Proposed Residential Development

Station Road, Royston

DR/13273/TN01 - 11 September 2015

Station Road, Royston
Residential Development

**PROPOSED DEVELOPMENT
AT
STATION ROAD
ROYSTON
HOUSE TYPE 2
(1257 sq.ft./ 116.67 sq.m)**

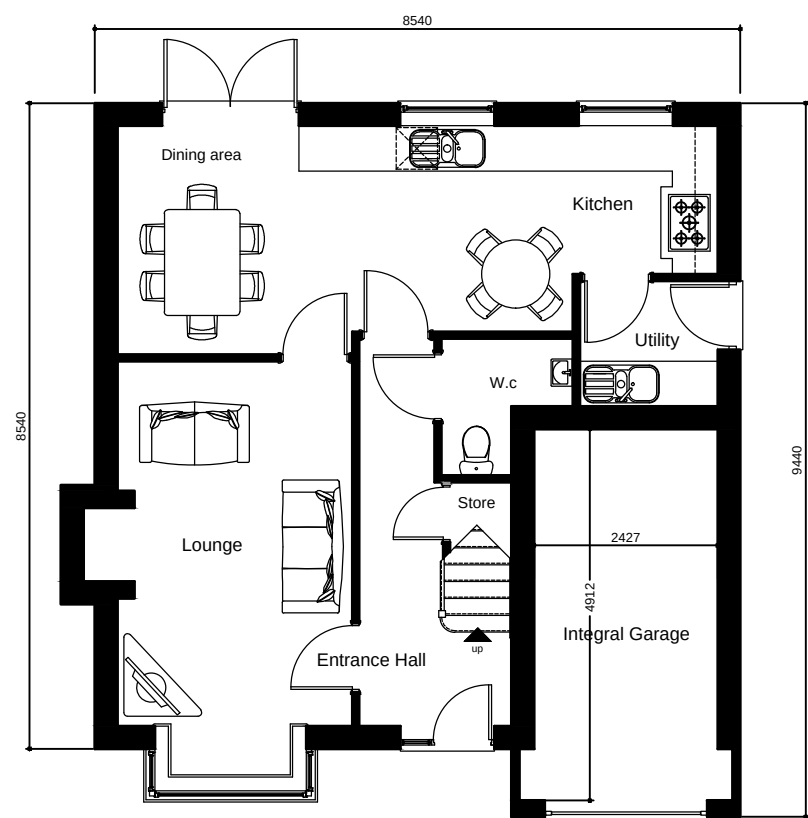
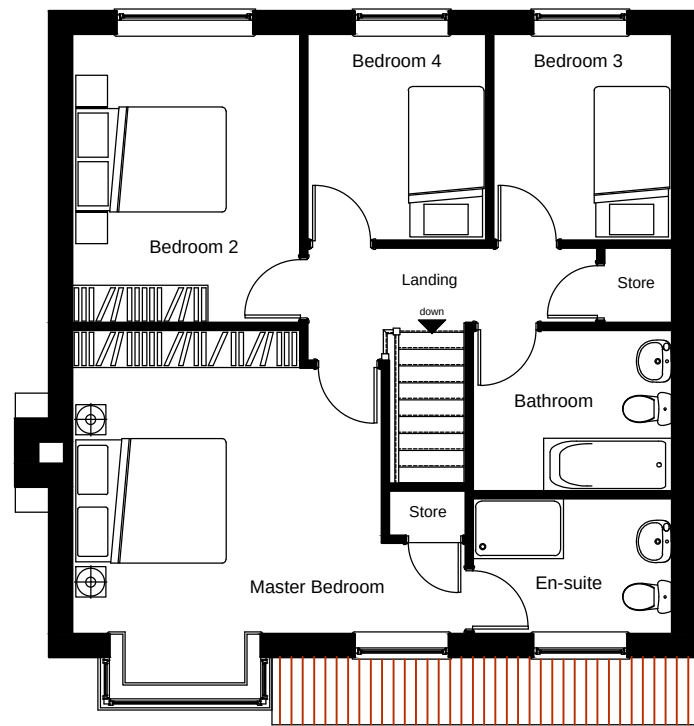
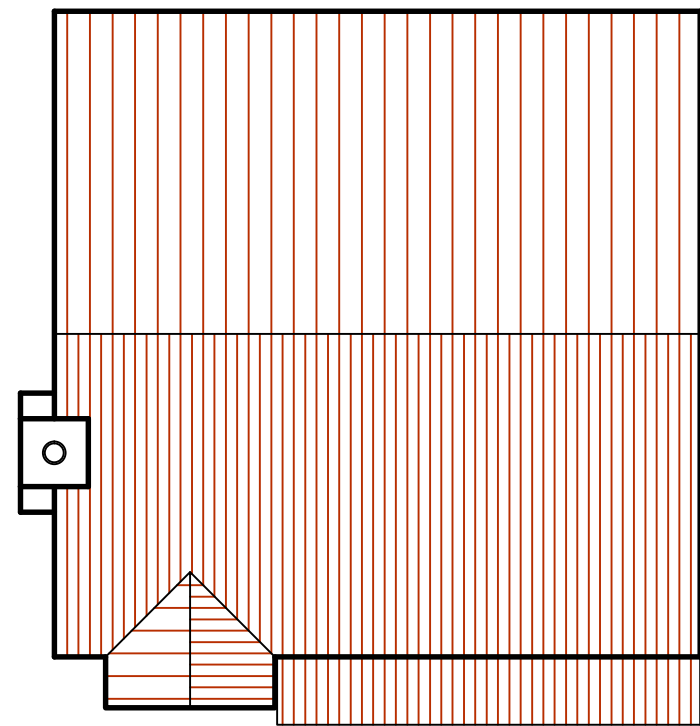
6. The garages do not comply with the minimum requirements of the South Yorkshire Residential Design Guide and cannot, therefore, be counted as a parking space. Parking spaces should also meet the minimum requirements of the Guide.

5. Plots 13-15 continue to be served by a private drive.
6. All detached garages have been amended where necessary to achieve the minimum internal dimension requirements of 3.0 x 6.5m. Parking spaces have also been amended where necessary to comply with the minimum dimension requirements of 3.3 x 6.0m in front of garage doors. Plot 1 has been revised to be a 1381 type with a detached garage. Plot 12, a 1257 type, has a garage below the 3.0 x 6.5m standard, but now has 2 no. off-street parking spaces.
